CITY OF PORTLAND, MAINE

Project Name:	Townhouses Units and Hotel/Restaurant	Project ID:	2017-056
Address:	749 Congress Street	CBL:	047 A020001
Applicant:	Denovo, LLC		
Planner:	Shukria Wiar

SUBDIVISION AND SITE PLAN PHASING PLAN
749 Congress Street
Subdivision Plan and Level III Site Plan Amendment
Project ID #2017-056
Denovo, LLC, Applicant

Submitted to: Portland Planning Board Public Hearing Date: April 13, 2017	Prepared by: Shukria Wiar, Planner Date: April 7, 2017
--	---

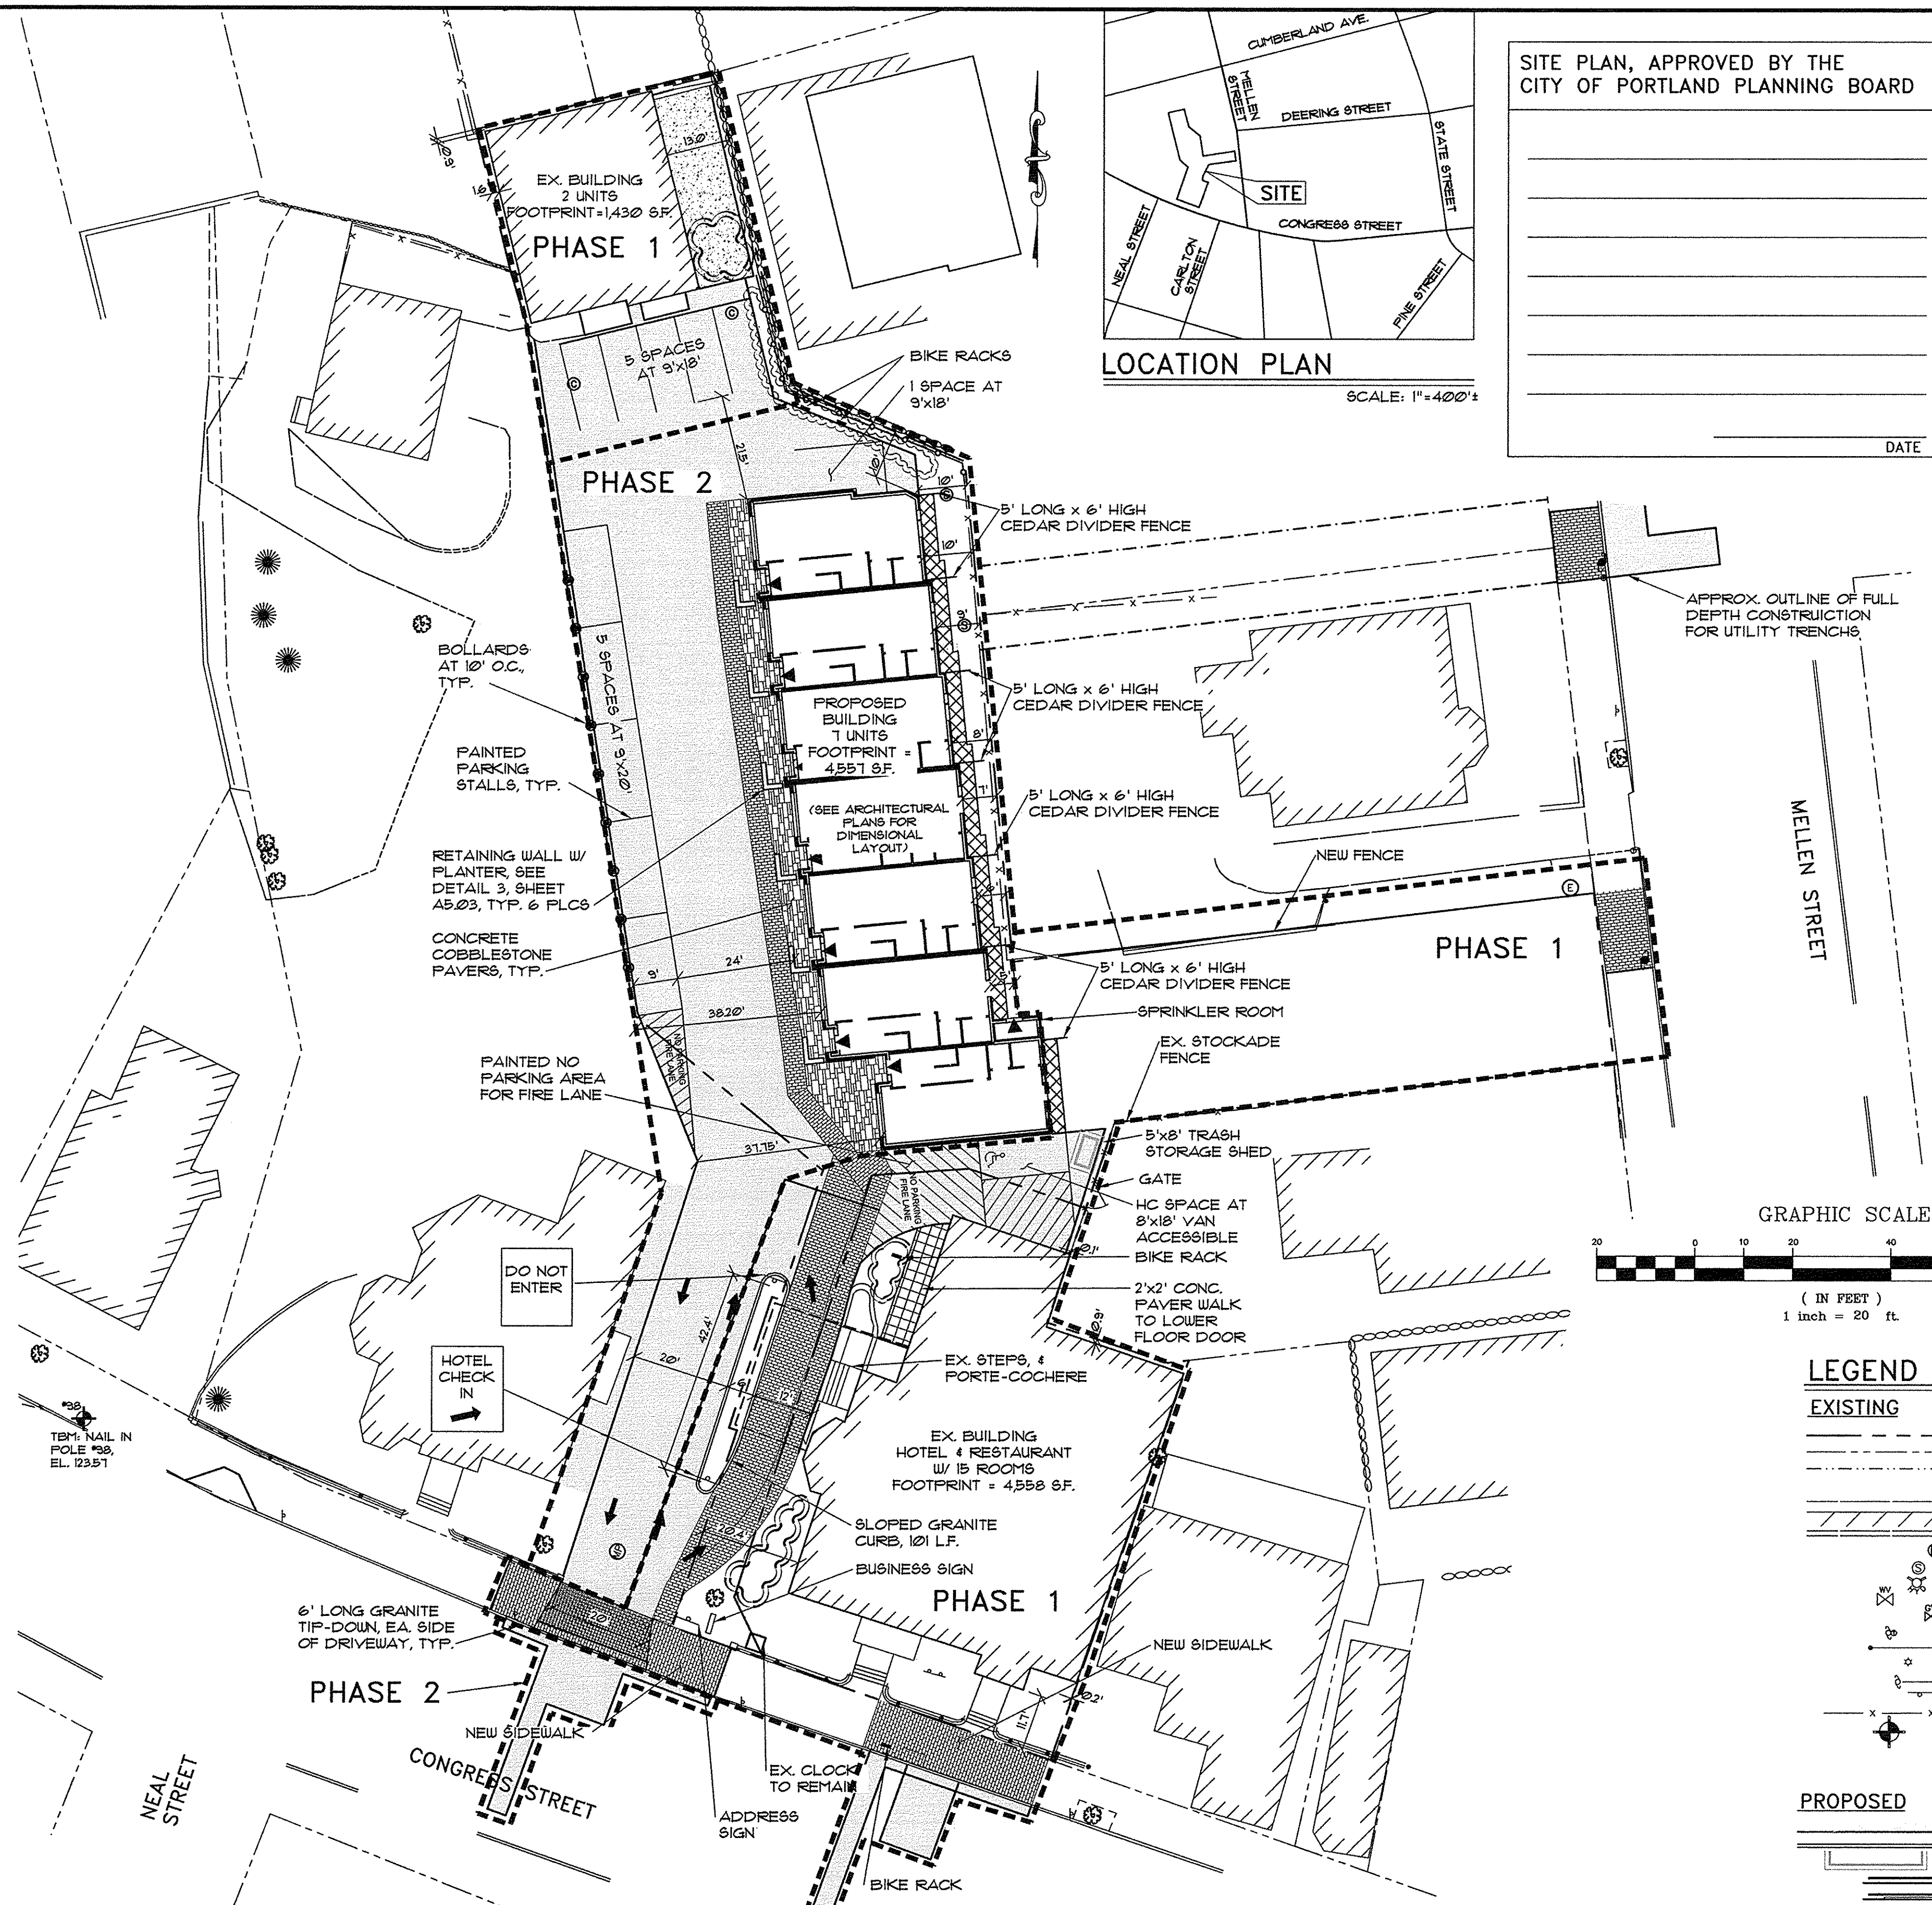
1. The handicapped parking space shall be included as part of Phase One of the project.

The applicant is not proposing any changes to the approved site plan other than to have this project into two phases. The Planning Authority does ask that the handicapped spaces be provided as part of phase one rather than phase two.
